FIRE RISK MANAGEMENT, INC

Memo Report

From: W. Mark Cummings, P.E.
To: Ms. Katherine Detmer; Archetype Architects
Subject: **Fire Protection of Reinforcing Steel in Roof Trusses; Brick South Building at Thompson's Point**

Drawing file: Revised plans 3-23-2017 / Brick South FP-01 REVISED LAYOUT w-STEEL PROTECTION  2-16-17.pdf

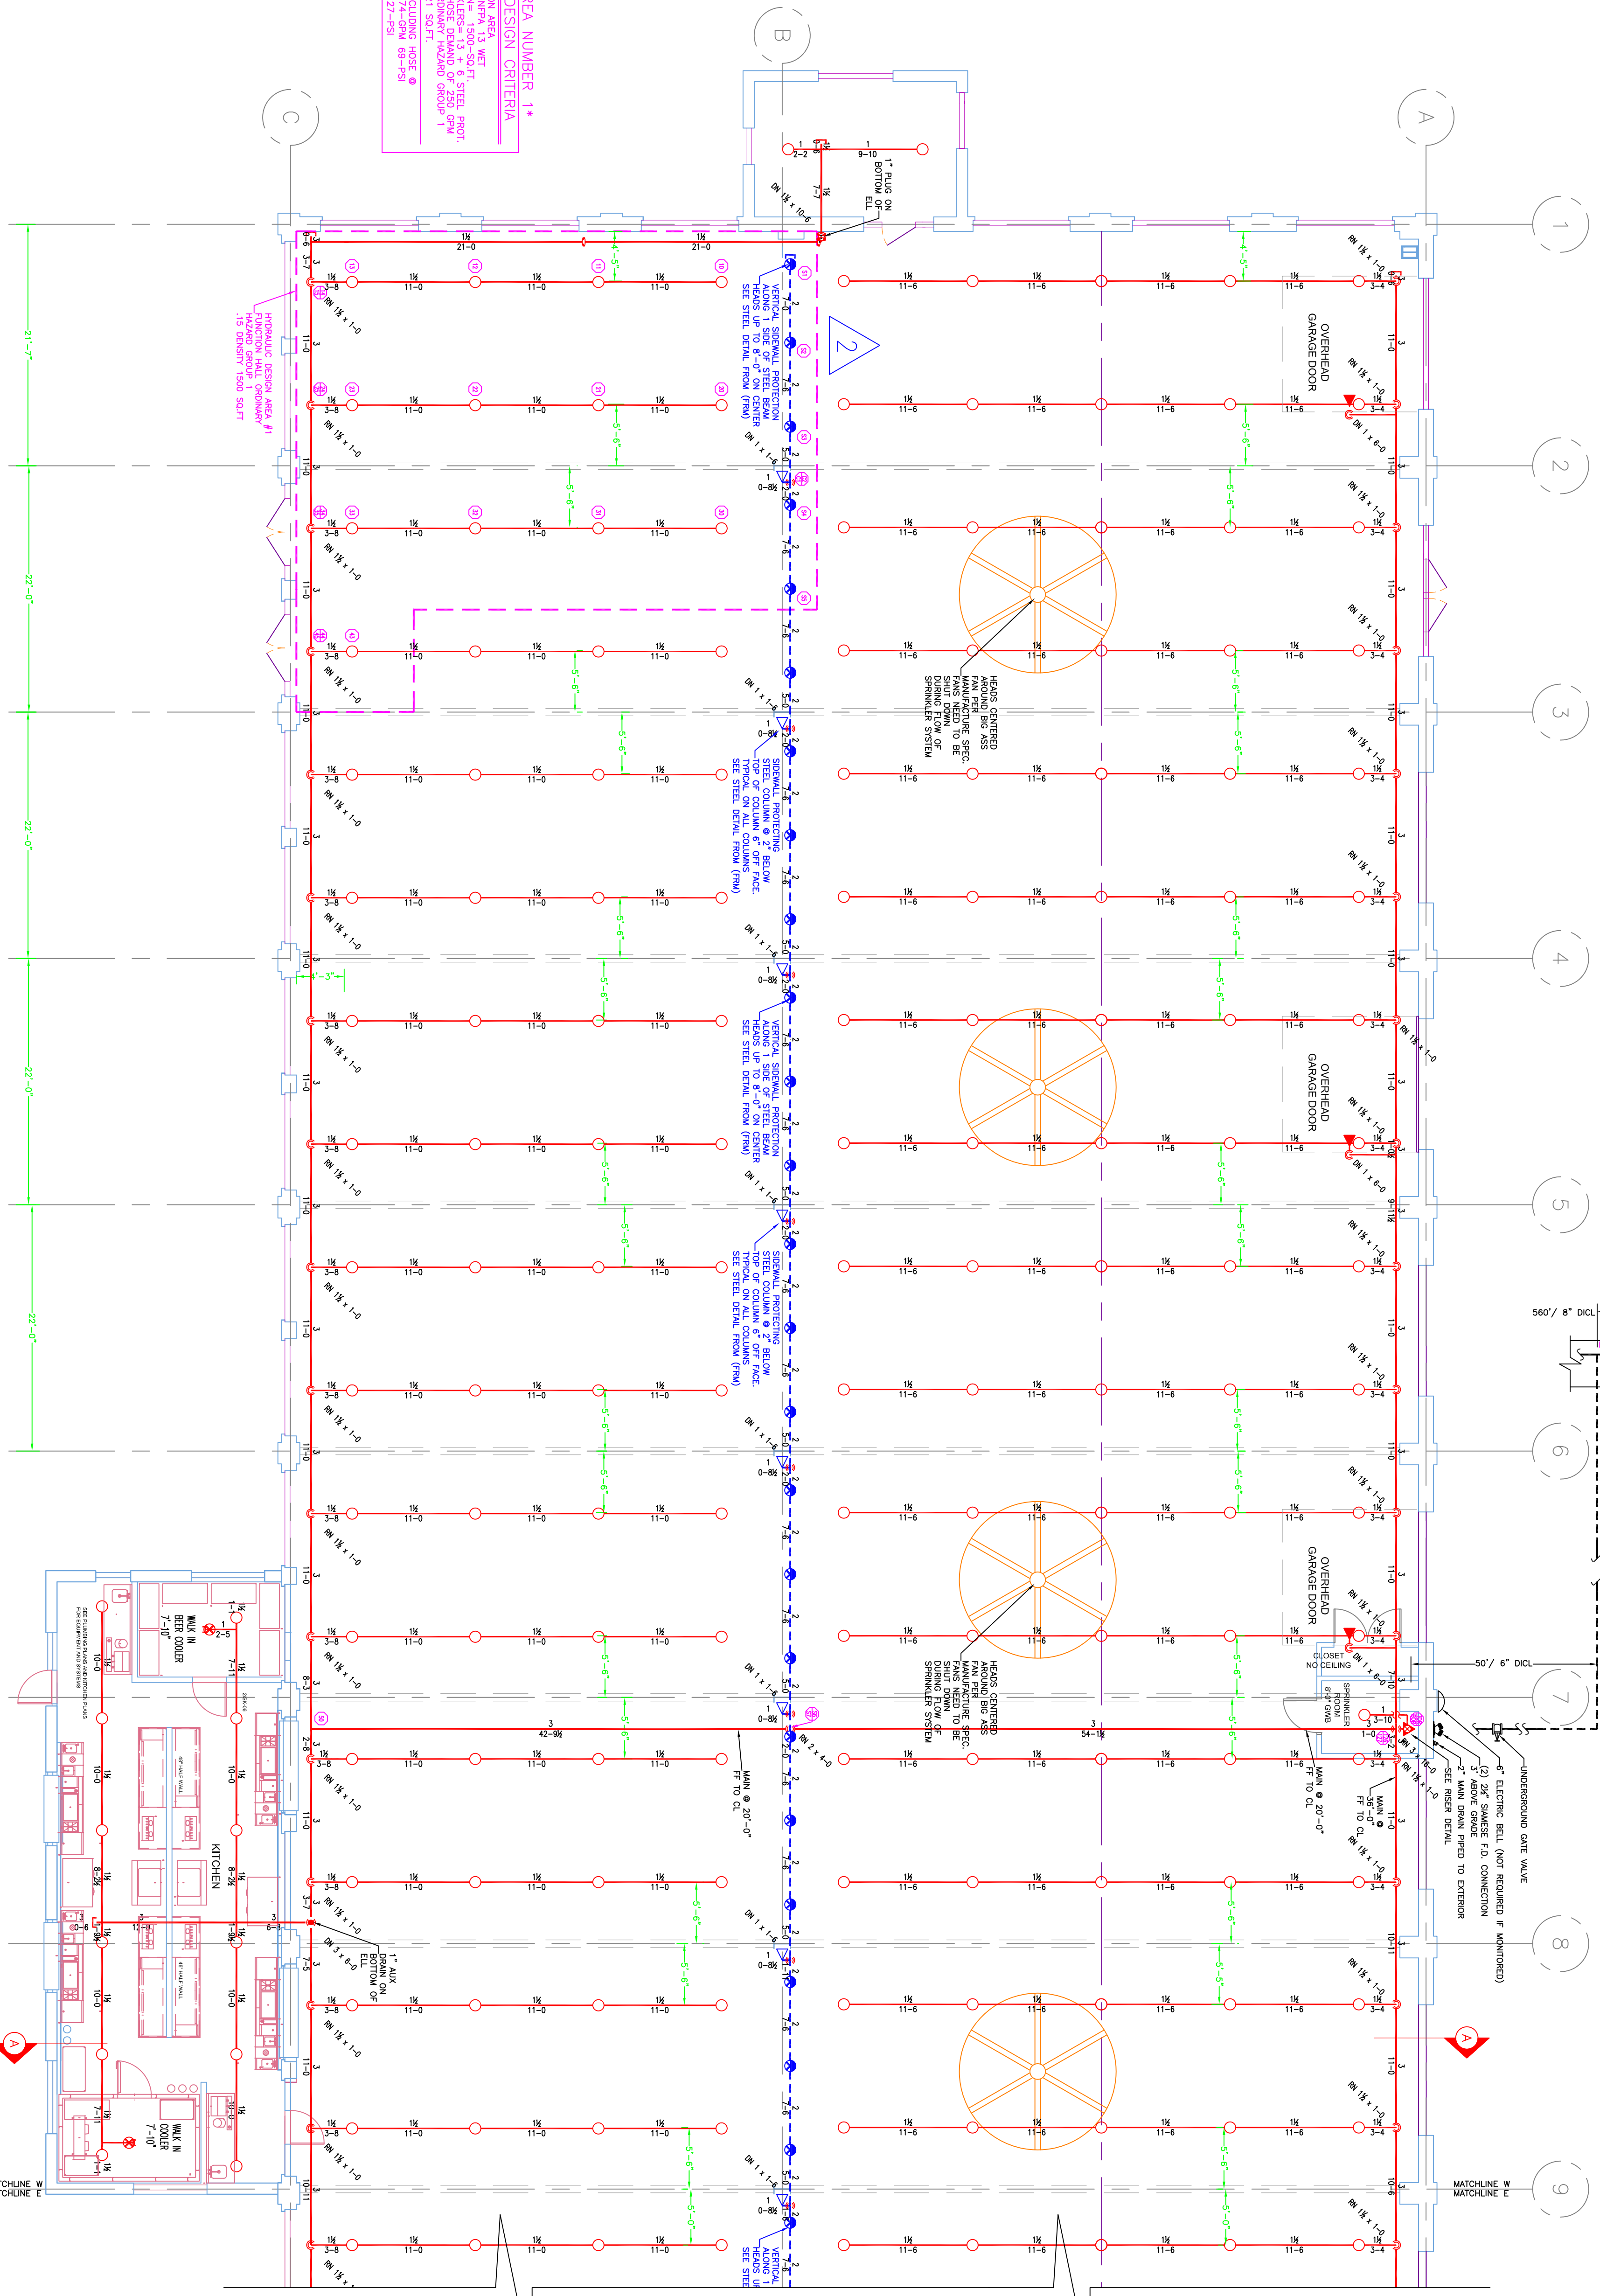
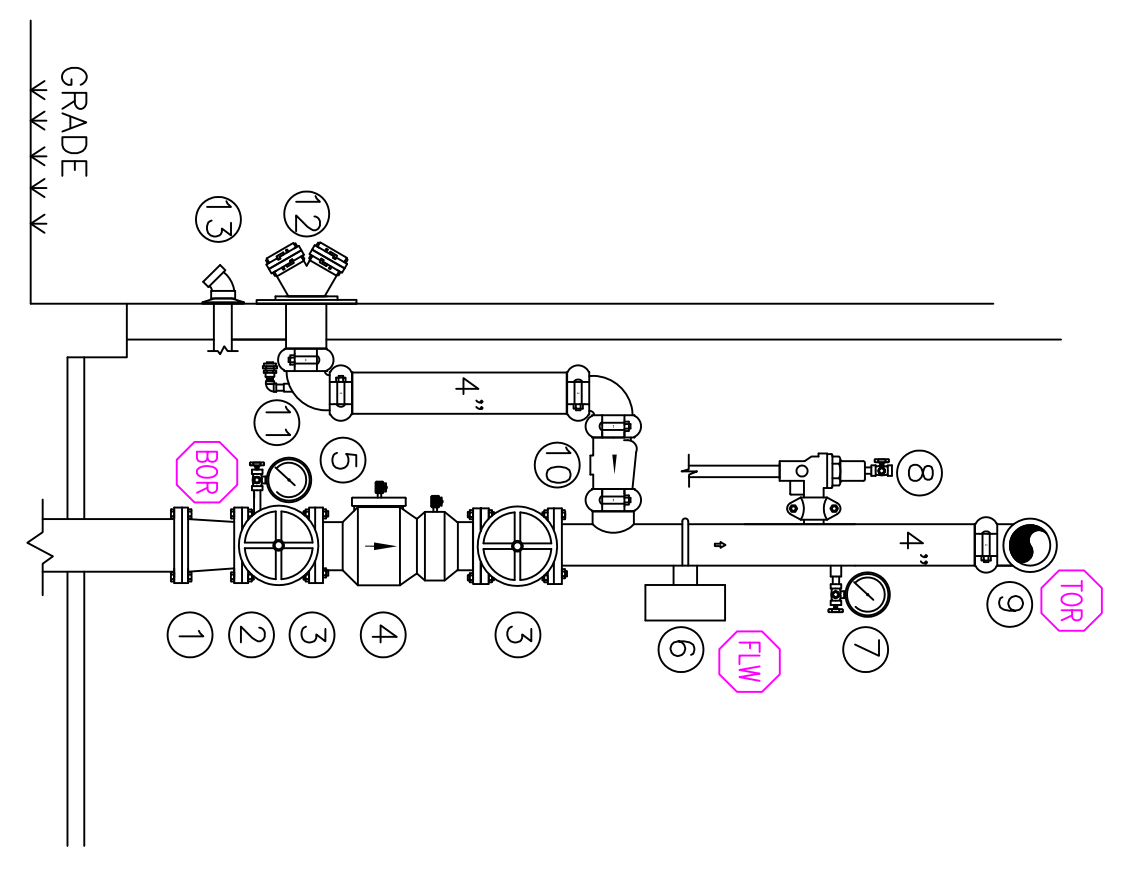
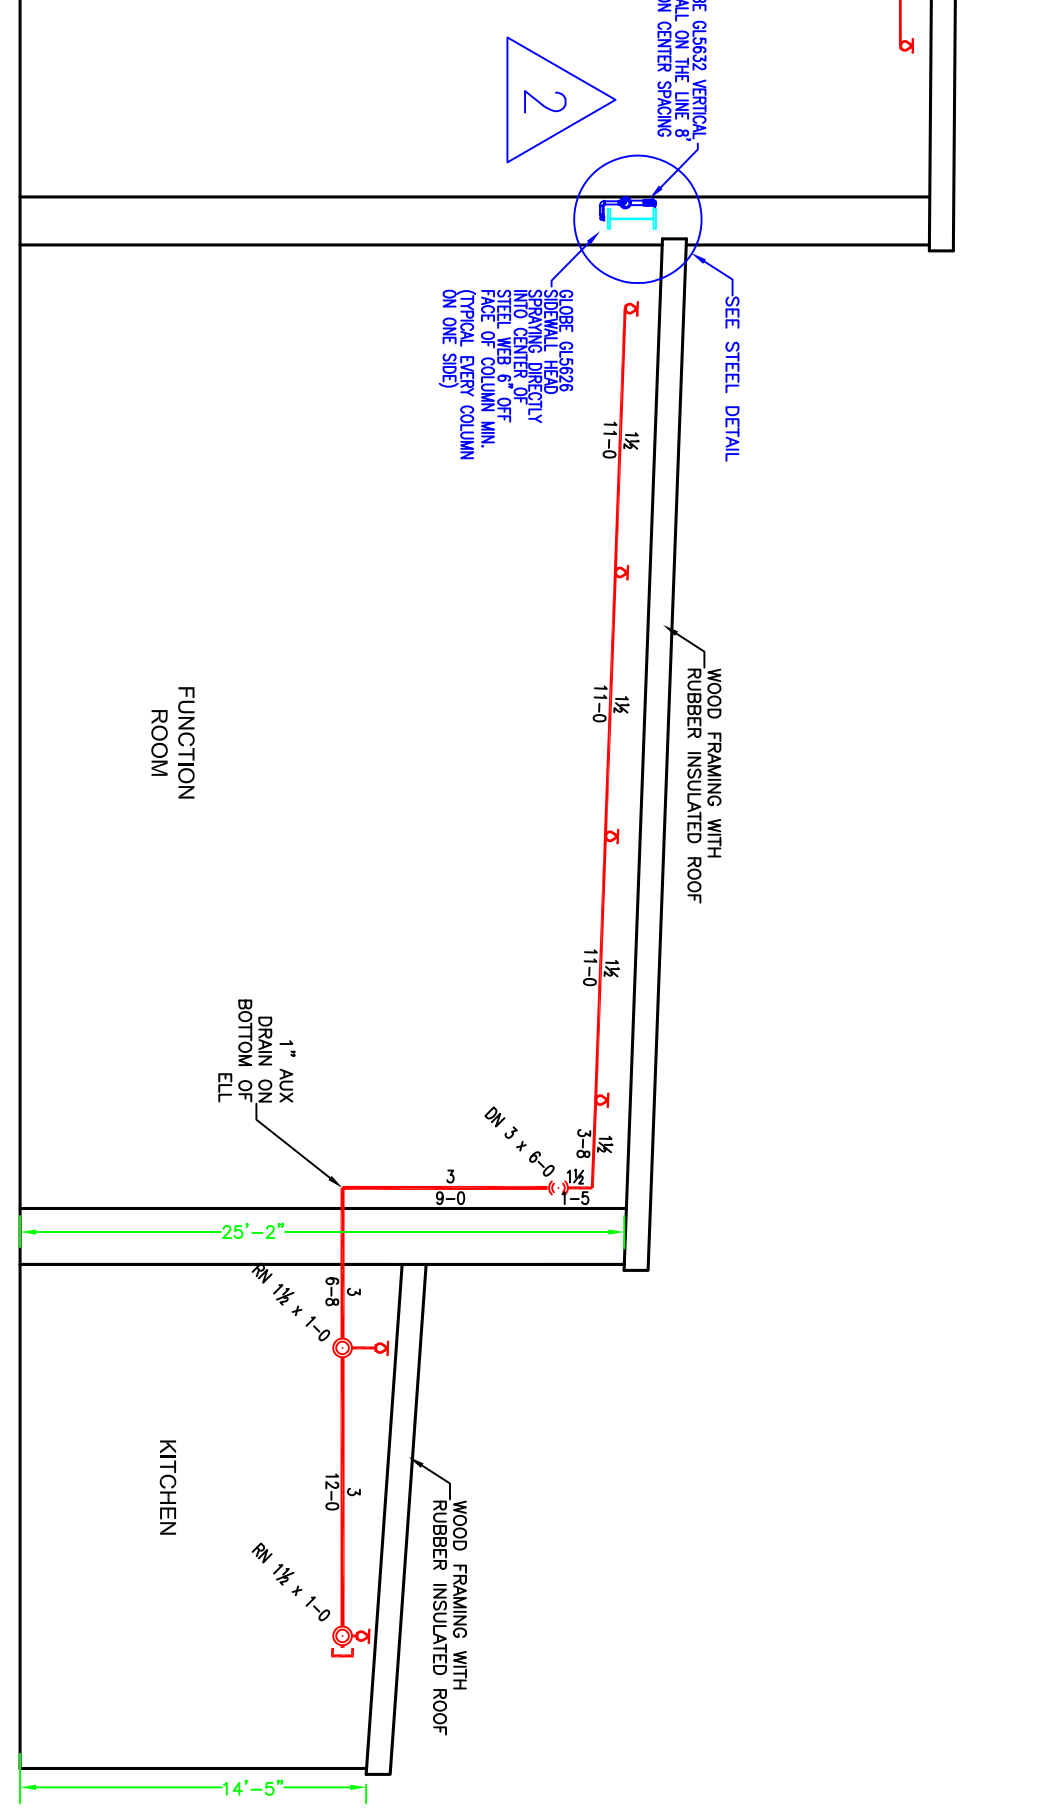
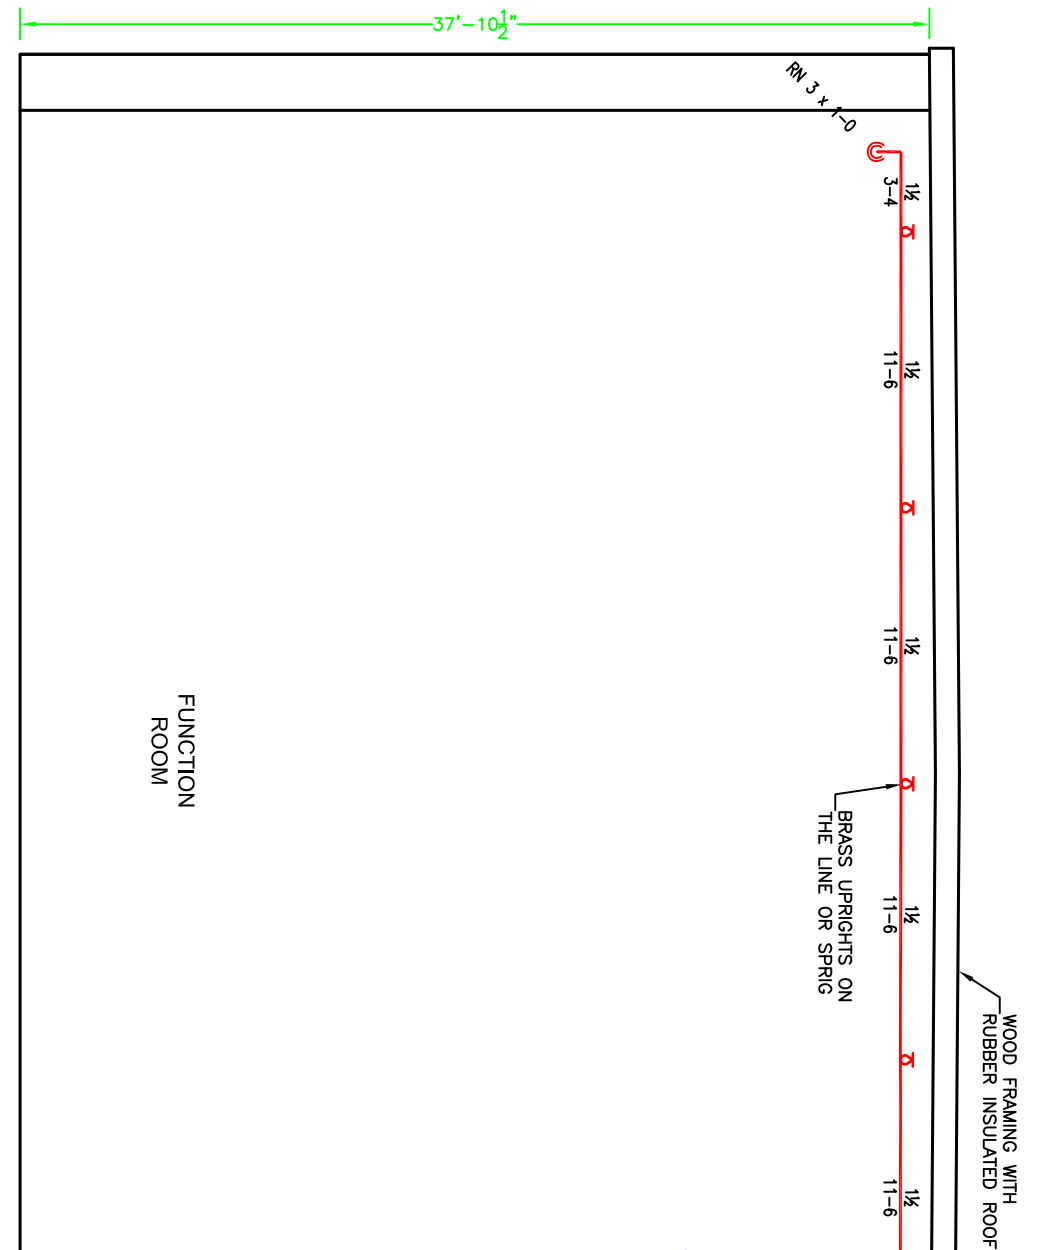
I have reviewed the technical data sheets you have provided for the two 3M™ products you have selected; the *Interam™ Endothermic Mat* and the *Fire Barrier Moldable Putty Pads*. As indicated in the sketch you provided, the pads will be used to protect the exposed steel rods between the upper and lower chords of the truss, with the putty being applied to the steel plates, nuts, and exposed threaded ends of the tie rods. Based on the data provided by manufacturer, your approach appears to be viable, but with one primary caveat; the materials must properly adhere to the steel components. This can be either a function of the material properties of the fire rated products themselves, in that they will adhere to the steel and/or wood without the need for any additional, external devices, or they must be held in place using other devices/materials approved for such use by the manufacturer. It must be verified that these materials can be properly applied over the steel

components in a manner consistent with their tested/listed configuration, including any associated installation limitations, such that any exposed steel is fully covered by the proper depth of material and that the materials will remain in place throughout the fire exposure period. The manufacturer may be able to provide assistance with regards to developing the proper installation guidelines for their products for this specific application.

Based on an initial review of the materials being proposed to provide the additional fire protection for the exposed portions of the steel tie rods, if the selected 3M™ products can be properly applied to these components, it is expected that they can, in fact, provide the necessary fire resistance to allow the steel tie rods to maintain their structural integrity for at least one hour of fire exposure as needed to comply with the IBC construction requirements. Should there be any questions regarding this review/assessment, please do not hesitate to contact me.
